February 9, 2018

**RE: Claremont Commercial Filing No.2, Preliminary Plan, SP-17-004 – 2<sup>nd</sup> Review Response**

This letter responds to your January 16<sup>th</sup>, 2018 review letter relating to the above referenced project. Responses to review comments are shown in red below.

PRELIMINARY GRADING AND EROSION CONTROL PLAN

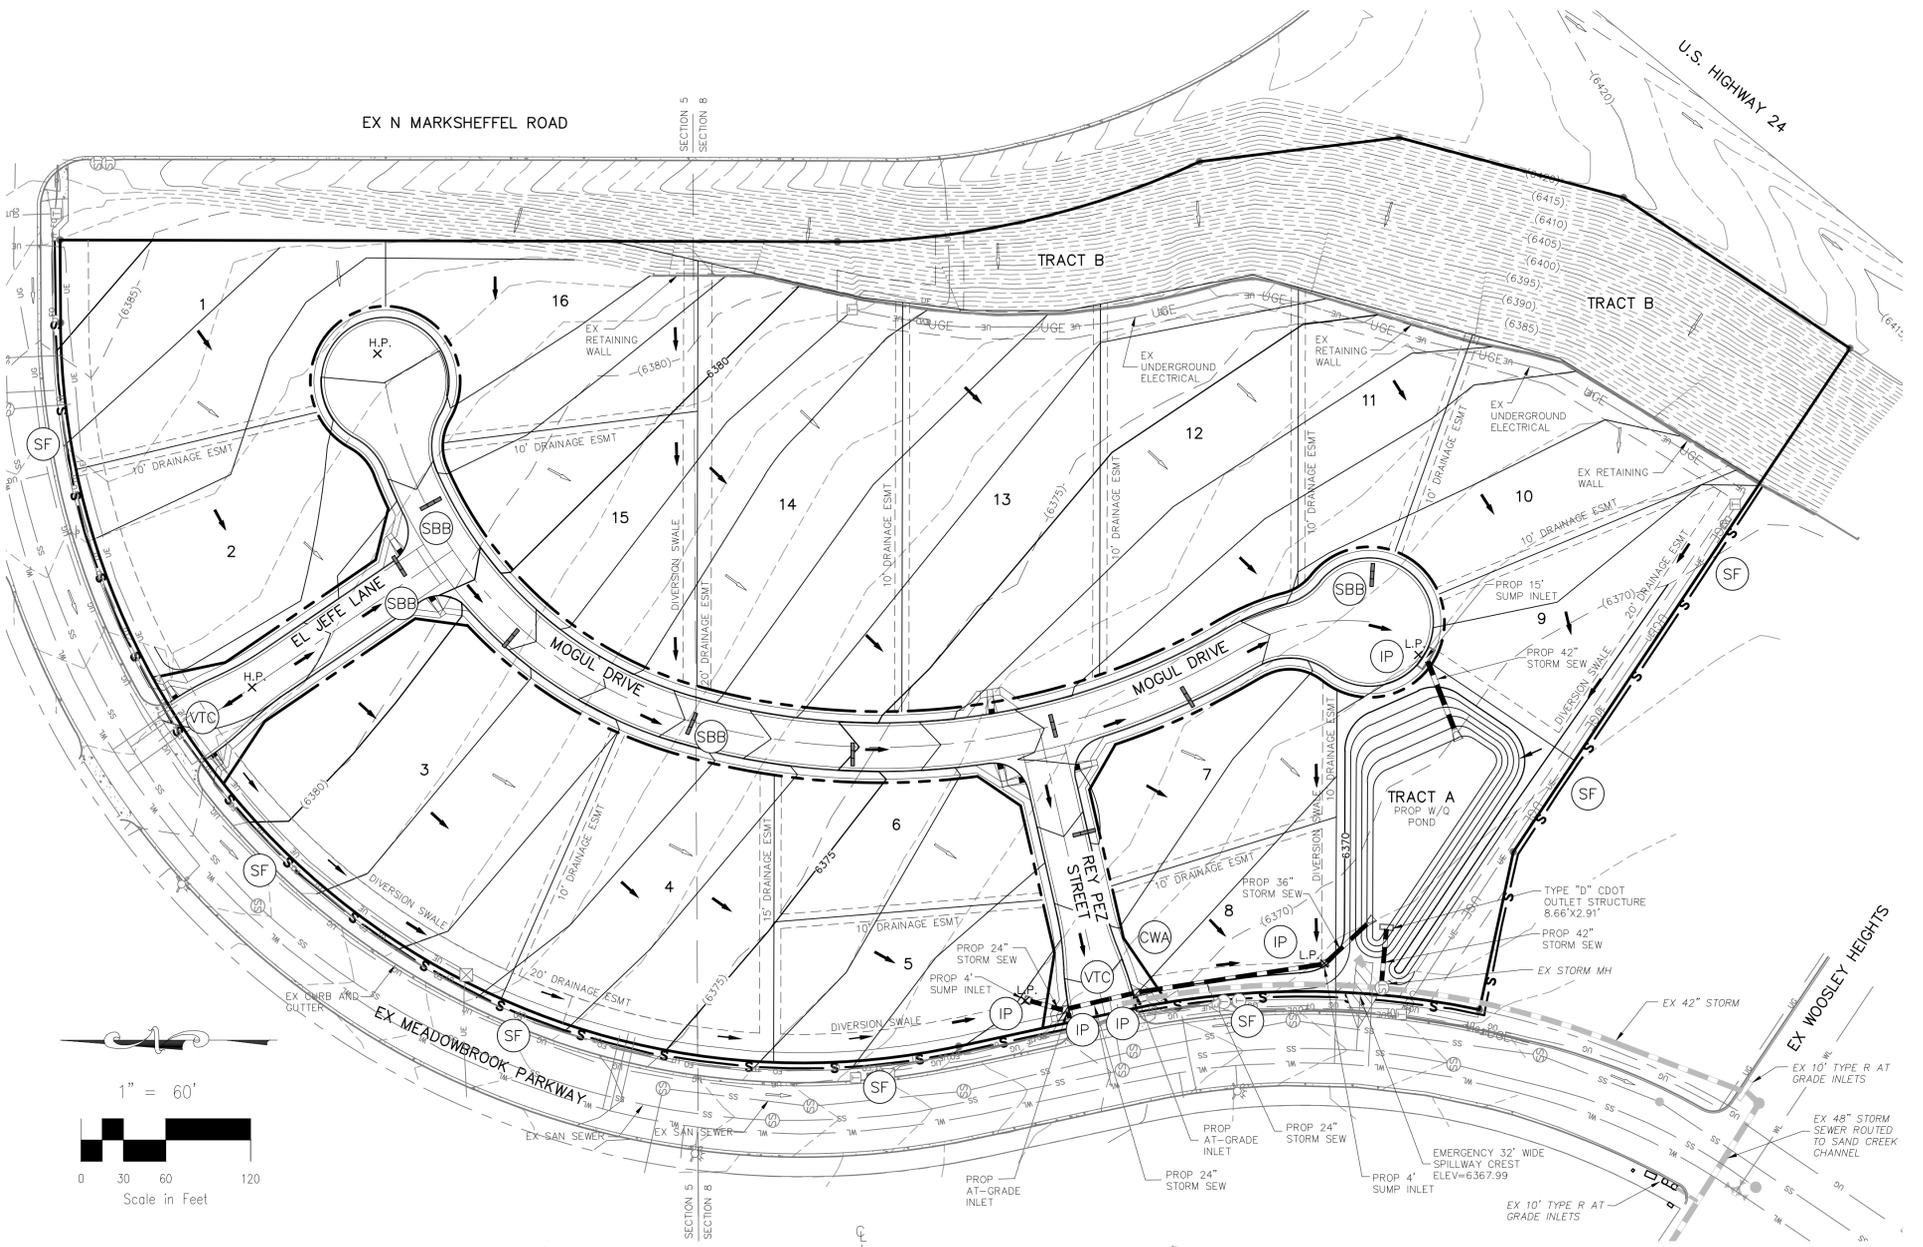
Comments resolved for the Preliminary Grading and Erosion Control Plan (GEC). Be advised: With the Final Plat the Grading and Erosion Control Plan shall be a standalone set with cover sheet and include all items listed in the GEC checklist in Appendix E of the ECM. The standalone GEC associated with the final plat shall include full construction details of the temporary and permanent BMPs. **Noted.**
